**From:**  
**To:** [Emily Stainer](#)  
**Cc:** [Planning](#)  
**Subject:** Fw: 3 Holme Close Hatfield AL10 9LQ - Proposed single story extension Daylight and Sunlight Matters  
**Date:** 31 January 2019 12:34:43  
**Attachments:** [Planning Letter 29 1 2019.pdf](#)

Application reference: 6/2019/0102/PN8 of 21st Jan 2019.

| Proposed Right & Left Elevation | YB |

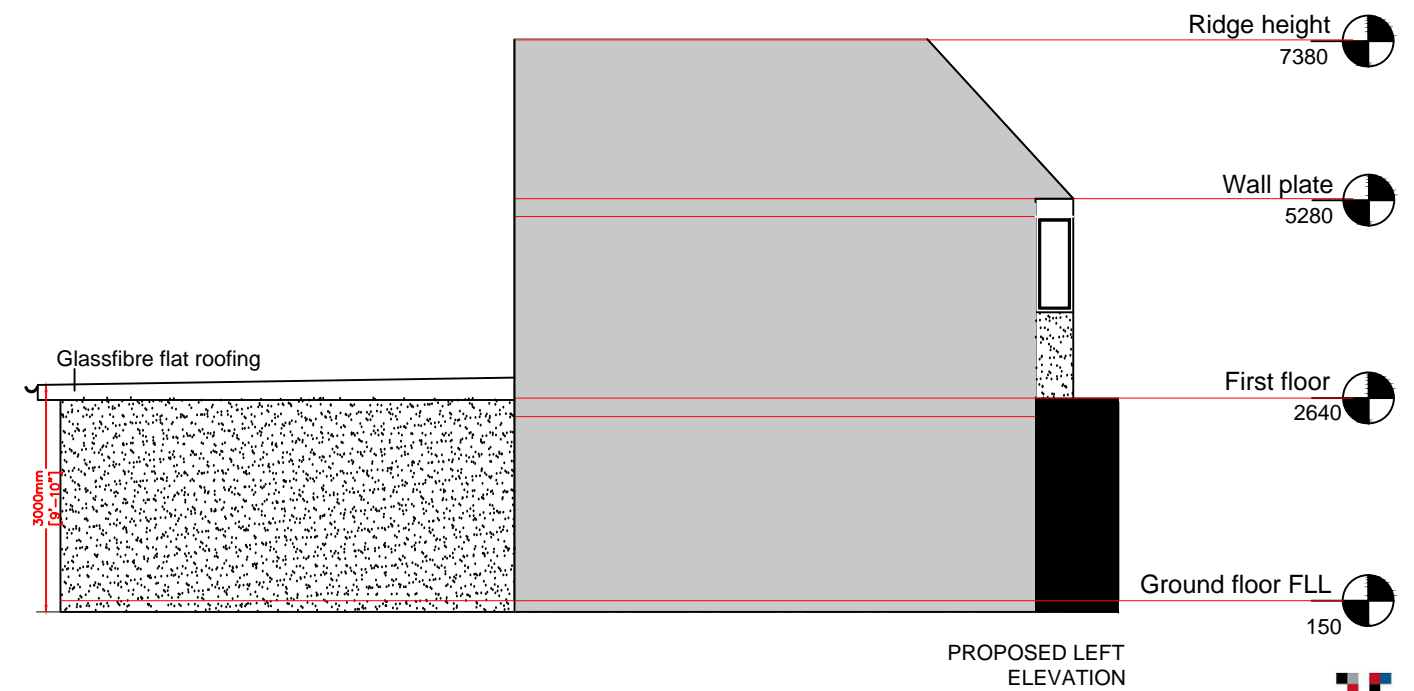
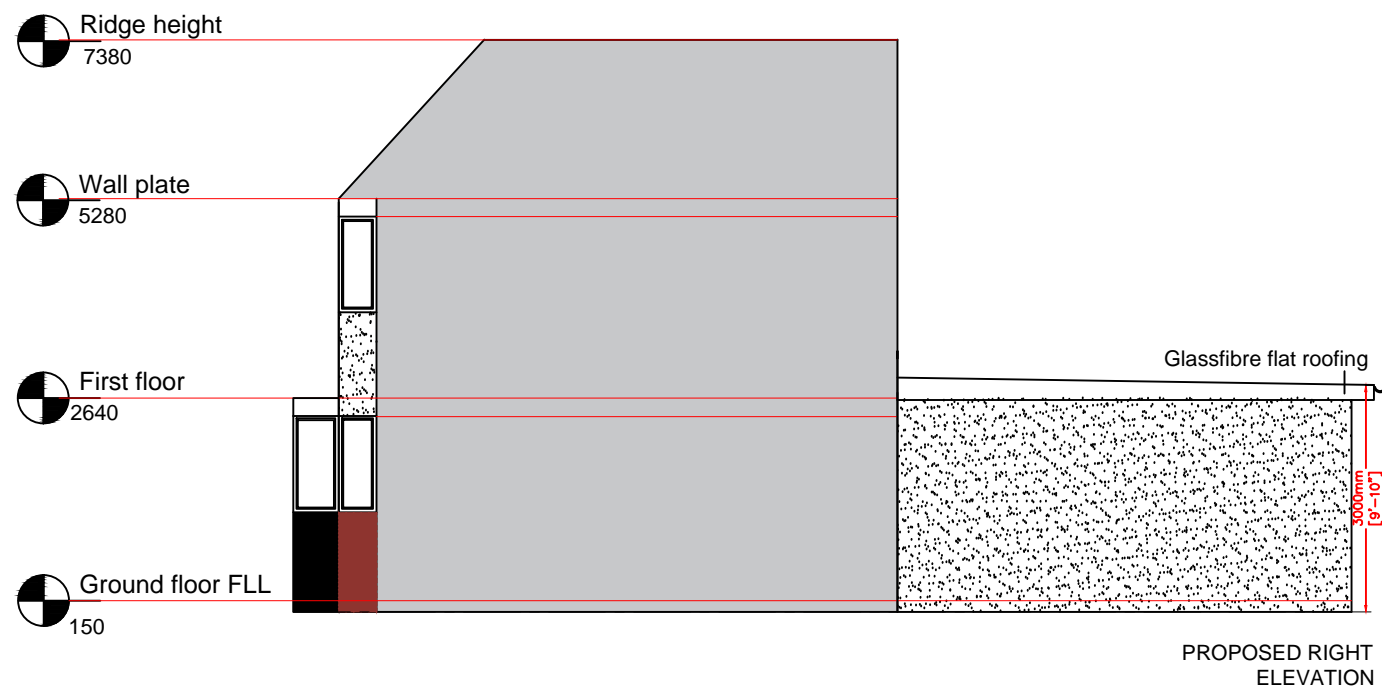
Looking at the proposed plans, I note that the maximum height is given as 3.1 metres.

I also understand the maximum height allowed is 3m only. I also would like the applicant to verify if the height given is from existing patio level, which is higher than ground level, or from original ground level as I believe the height has to be measured from the highest point of the natural surface ground adjacent to the development.

In addition I consider the proposed development size to be overbearing.
